CITY OF ALBUQUERQUE

**Re: CNM Smith Brasher Hall
Erosion and Sediment Control Plan
Engineer's Stamp Date 3-16-16 (K15E076)**

ESC 101

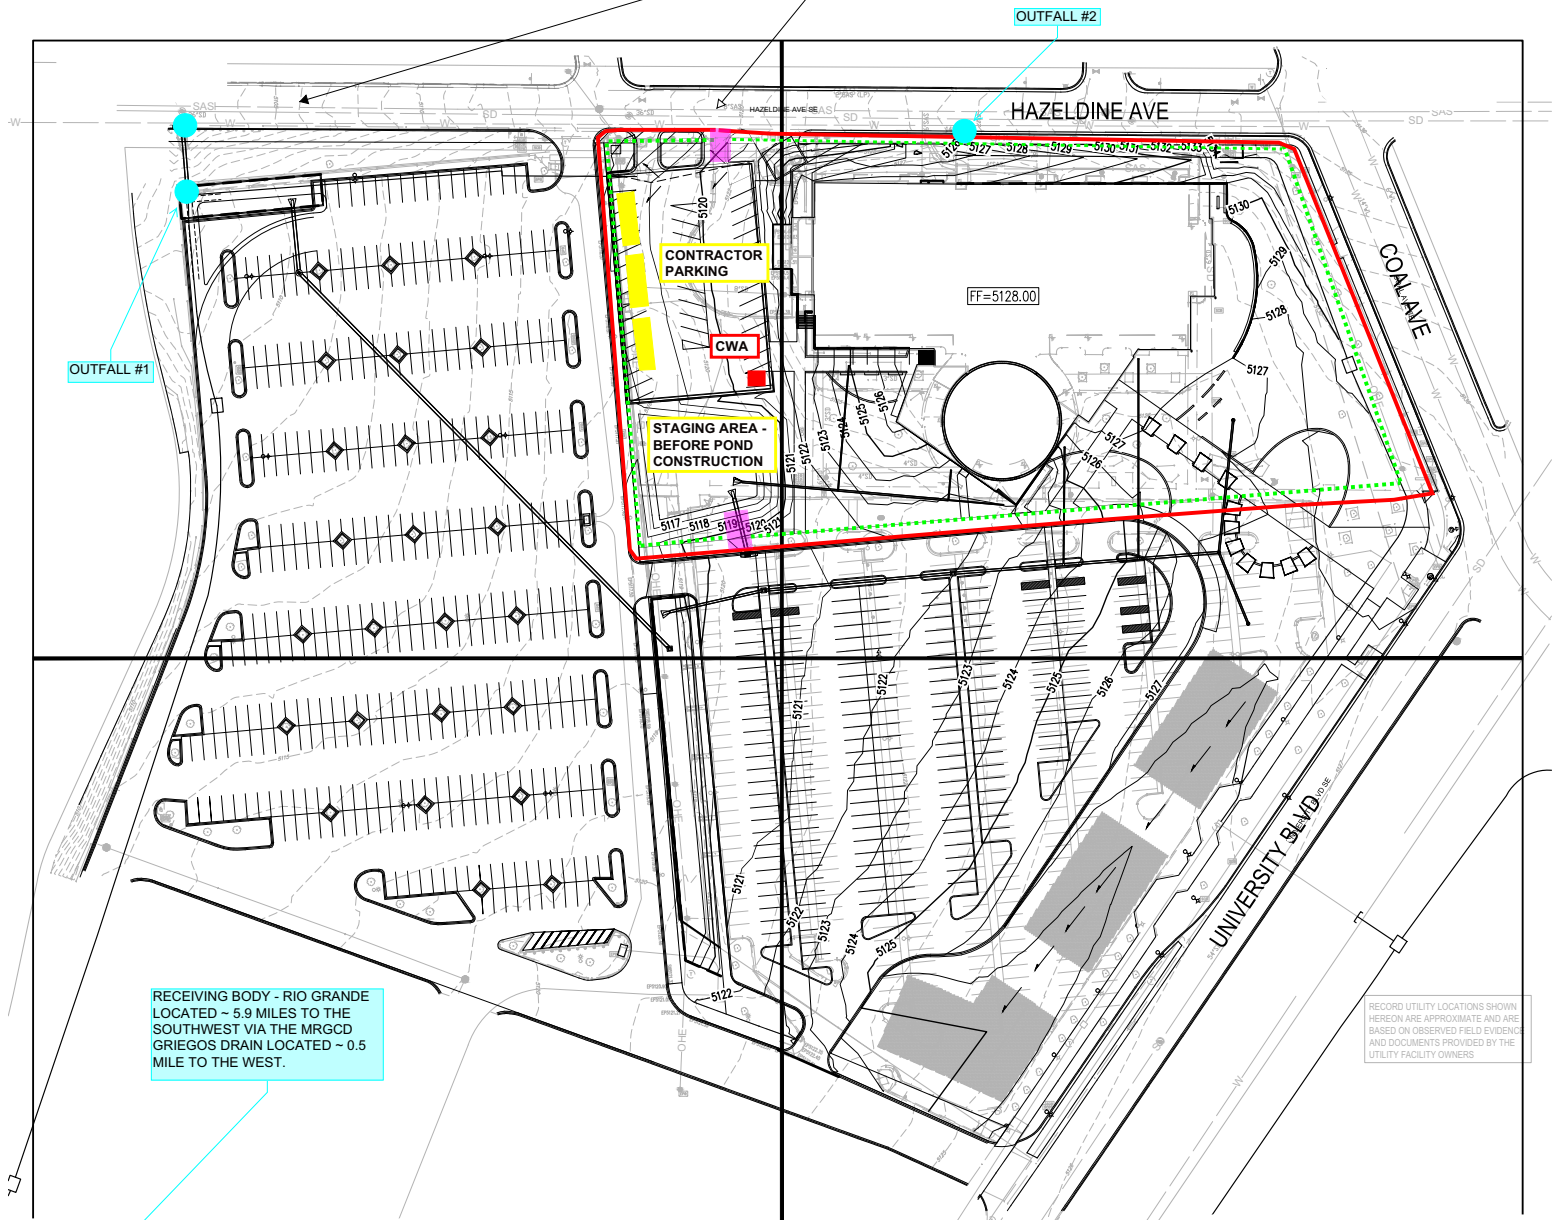
1. The plan does not show the construction or include BMPs in the public ROW. Utility cuts are proposed in Hazeldine Avenue and University Boulevard. For utility cuts in existing streets include a legend item and Keyed Note that the dirt should be placed on the uphill side of the street cut and the area swept after the work is complete.

2. Please add a note that "When doing work in the City ROW (e.g. sidewalk, drive pads, utilities, etc...) prevent dirt from getting into the street. If dirt is present in the street, the street should be swept every few days or the same day if rain is imminent.

3. When construction is occurring in the ROW uphill of the inlet shown on Sheet ESC 101 in Hazeldine Ave., should inlet protection be installed on the inlet?

4. When construction is occurring around the inlet shown on Sheet ESC 101 in Hazeldine Ave., inlet protection should be provided for this inlet.

5. There is an inlet 100 feet west of the inlet shown on Sheet ESC 101 in Hazeldine Ave., should inlet protection be proposed when construction (24" sd, utility cut) is occurring at the northwest corner of the site in the ROW?
